**Our ref:** XA/2024/100119/01-L01  
**Your ref:** EN010163

**Date:** 6 August 2024

**PLANNING ACT 2008 (AS AMENDED) AND THE INFRASTRUCTURE PLANNING  
(ENVIRONMENTAL IMPACT ASSESSMENT) REGULATIONS 2017 (THE EIA  
REGULATIONS)– REGULATIONS 10 AND 11 - SCOPING OPINION**

**APPLICATION BY RENEWABLE ENERGY SOLUTIONS (RES) (THE  
APPLICANT) FOR AN ORDER GRANTING DEVELOPMENT CONSENT FOR THE  
STEEPLE RENEWABLES PROJECT - LOCATED TO THE EAST AND WEST OF  
STURTON LE STEEPLE AND SOUTH OF WEST BURTON POWER STATION**

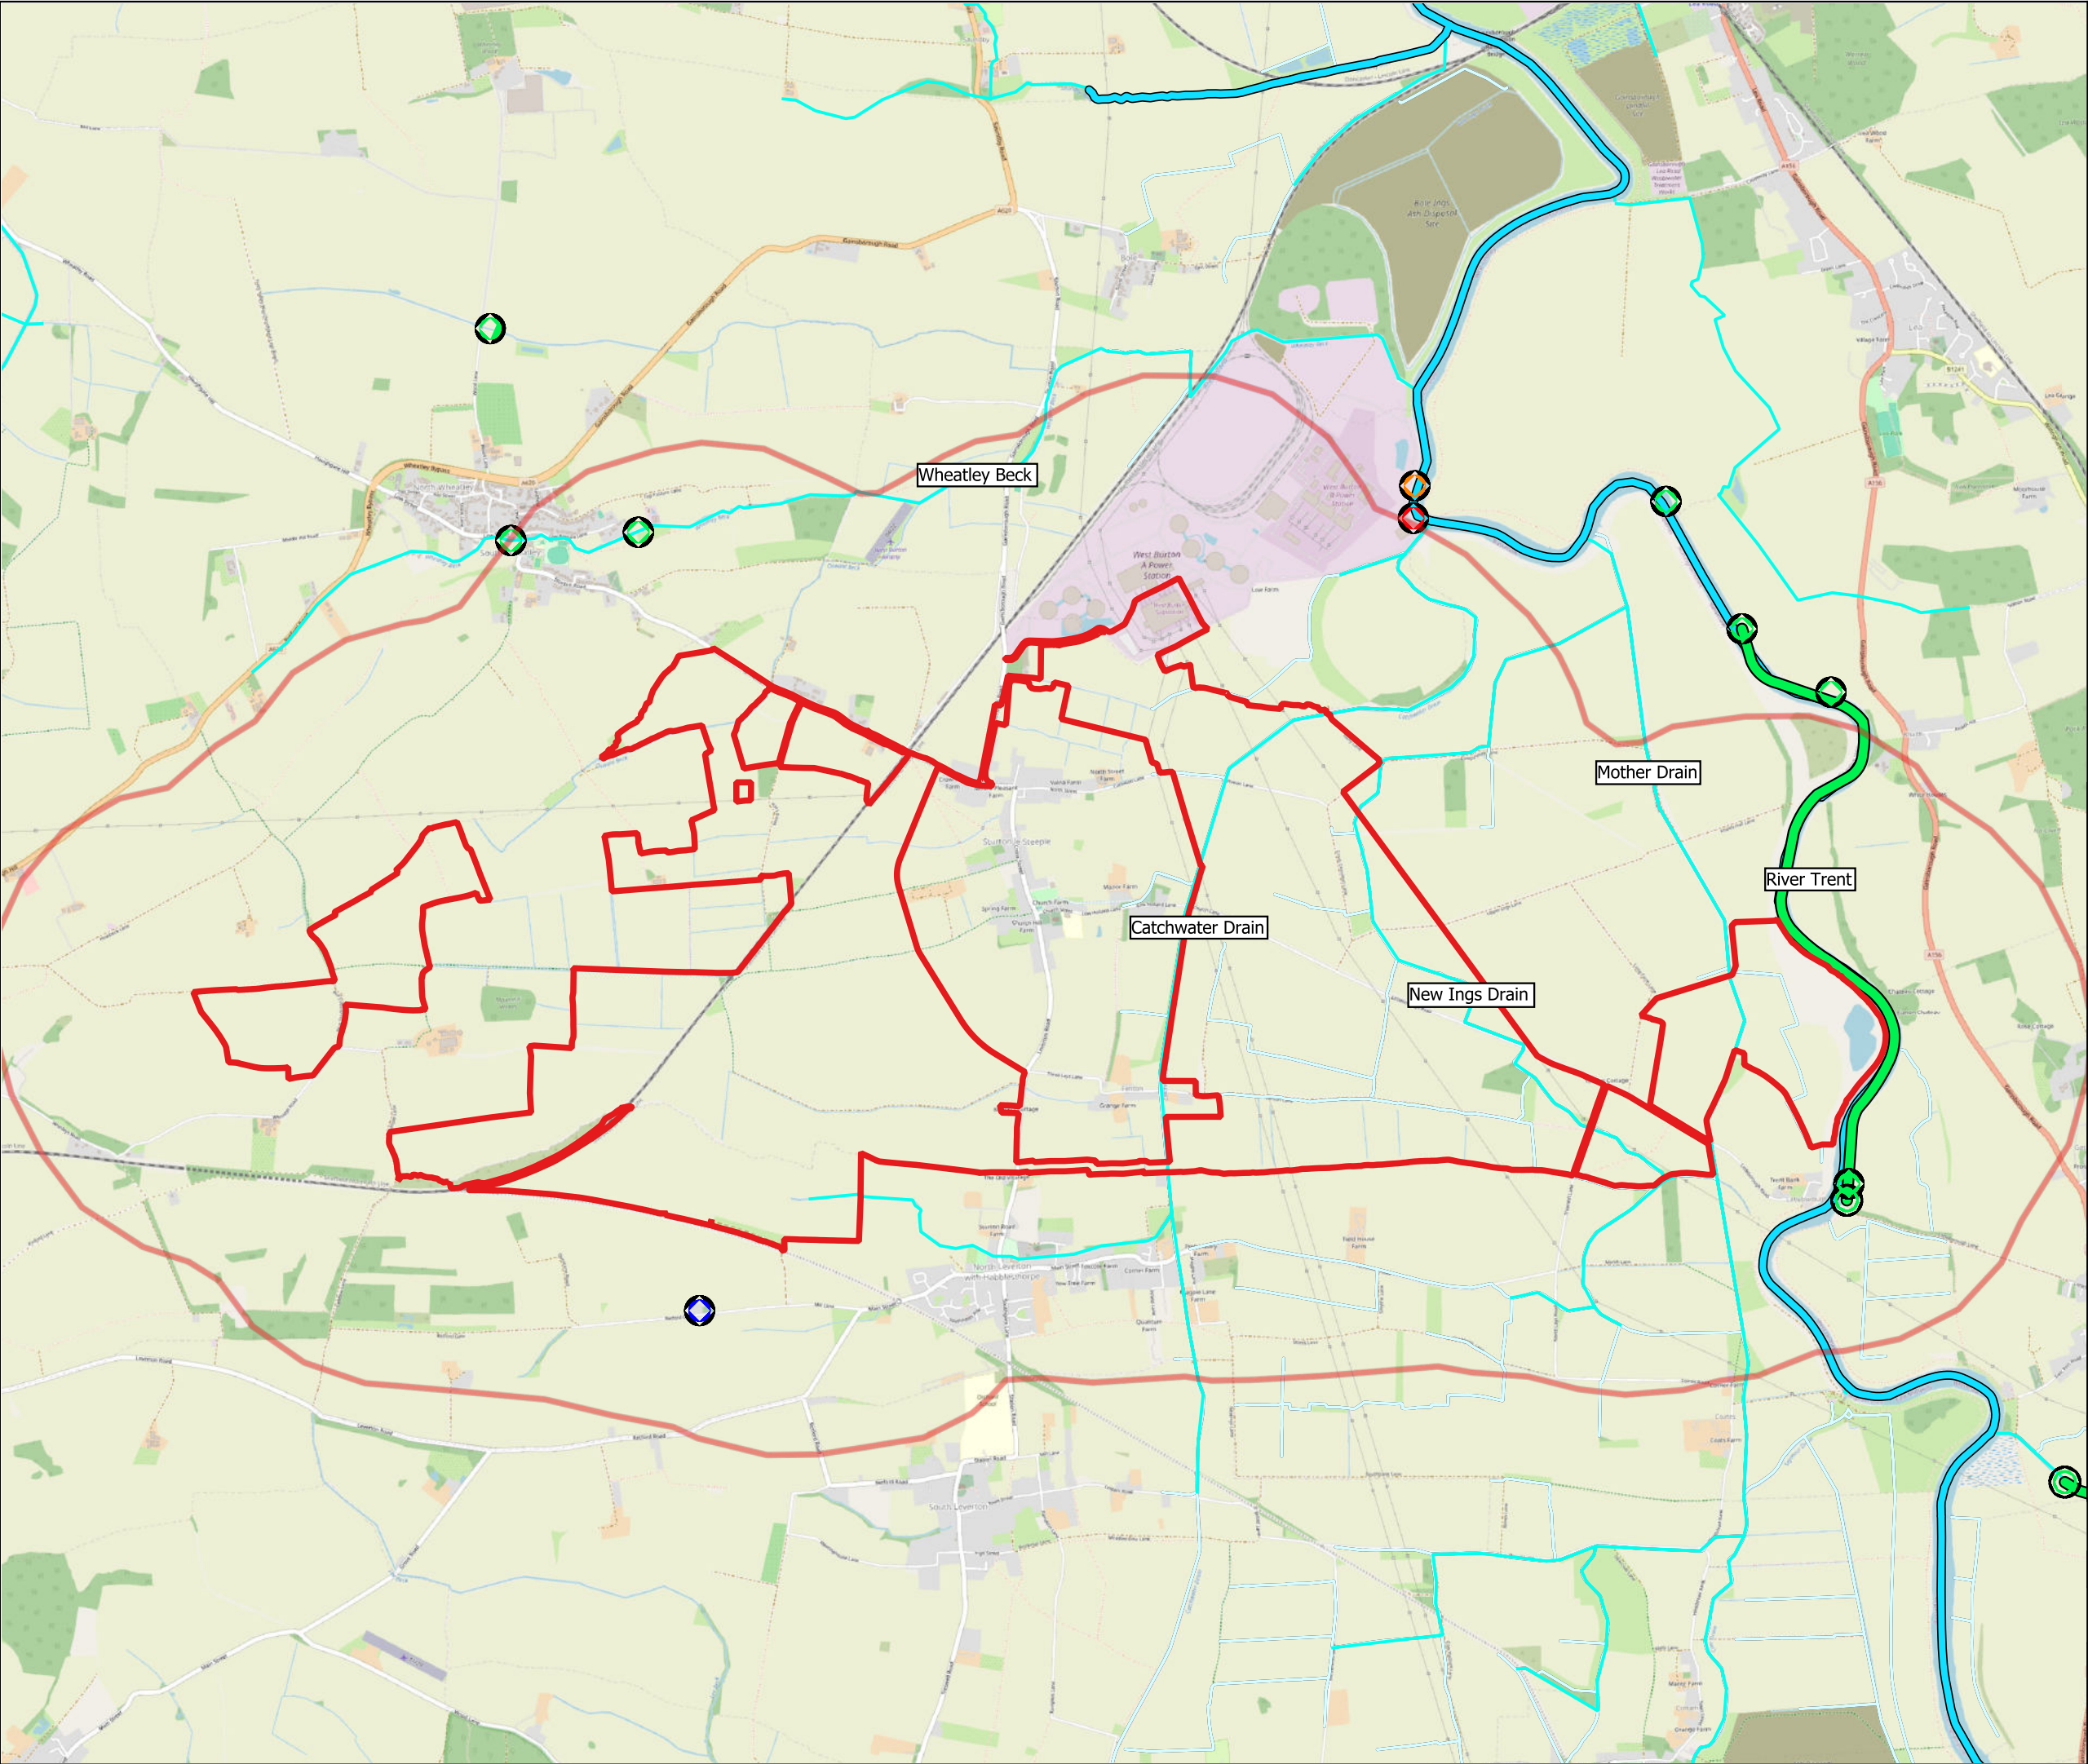
The baseline assessment list should include private groundwater abstractions.
